Kirkburton Parish Council comments on Kirklees Plan List 6 – 12 June 2022

The following applications were considered by Kirkburton Parish Council at the meeting on 7 July 2022. The Parish Council's comments are detailed below:

6 STATION ROAD,
SHEPLEY, HD8 8AA

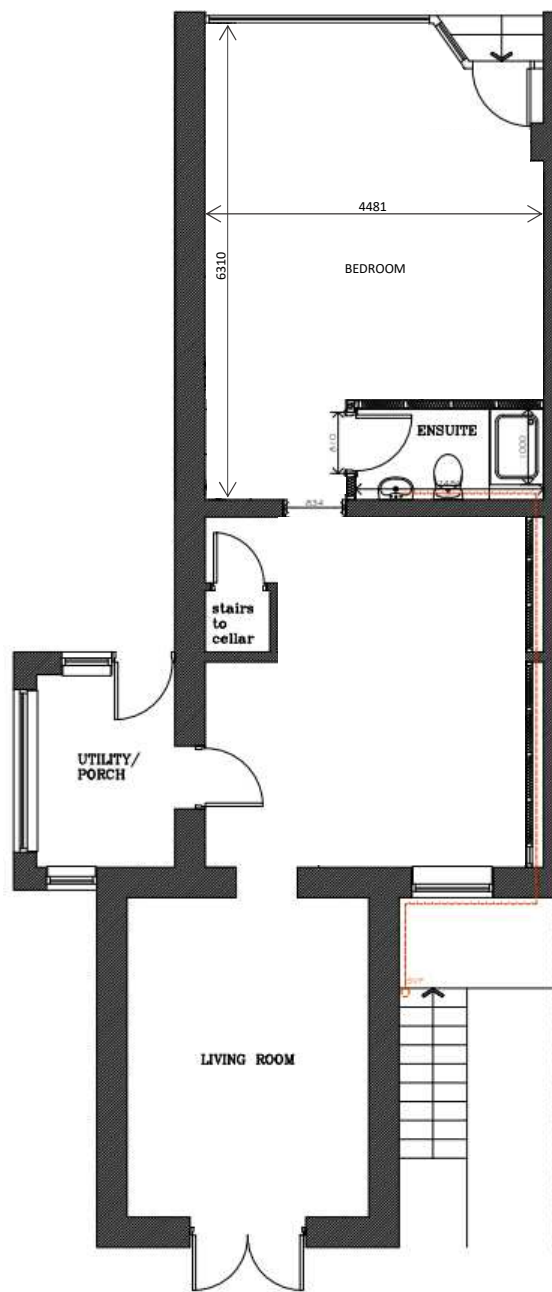
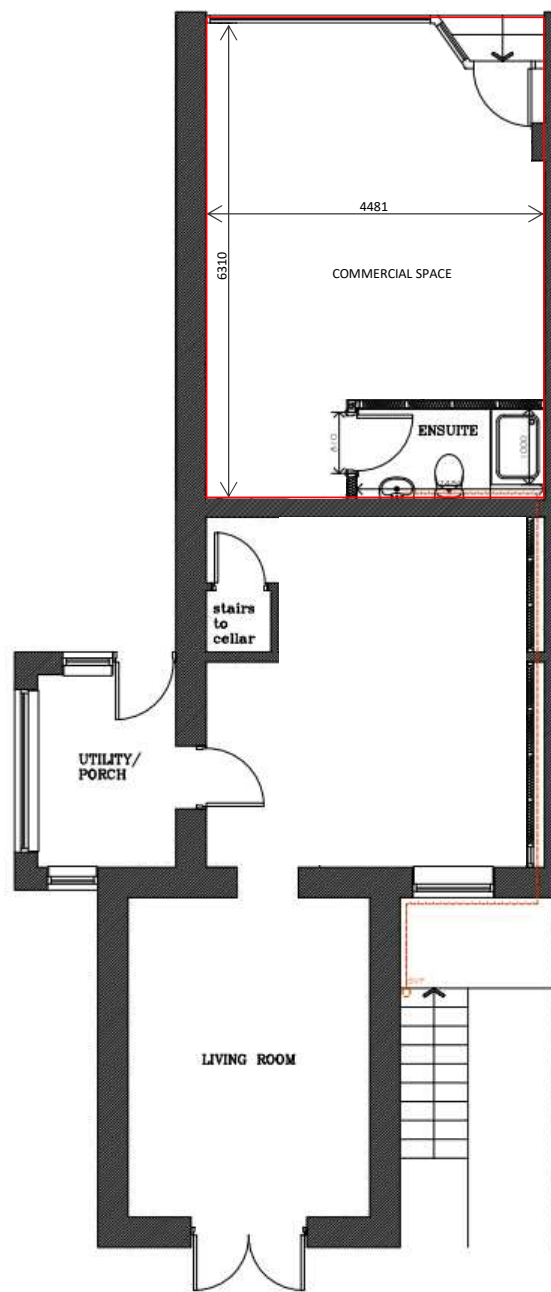
Application and Details	Kirklees Officer	Kirkburton PC Recommendation
2022/62/91896/E Shepley Newsagents, 6, Station Road, Shepley Applicant: K Jepson Description / Development: Change of use to class E semi-commercial (Within a Conservation Area) Deadline date for comment: See Monday 18 July 2022	Alice Downham	No comment
2022/62/91909/W International House, Penistone Road, Fenay Bridge (Lepton ward) Applicant: Paxman Coolers Ltd Agent: Robert Halstead Chartered Surveyors Office G of H, Bridge Mills, Huddersfield Road, Holmfirth Description / Development: Erection of first floor extensions to form office and storage space, re-configuration of internal layout to form additional and amended workshop space, storage space, and staff facilities, re-location of office space into proposed extension. and formation of 14 additional car parking spaces and bin storage area. Deadline date for comment: 11 July 2022	Ellie Worth	The Parish Council objects on the grounds that it is a significant development in this area, and it needs an access with increased visibility. The access also needs improvement as the current design combined with the width of the road would make it difficult larger vehicles to use it.
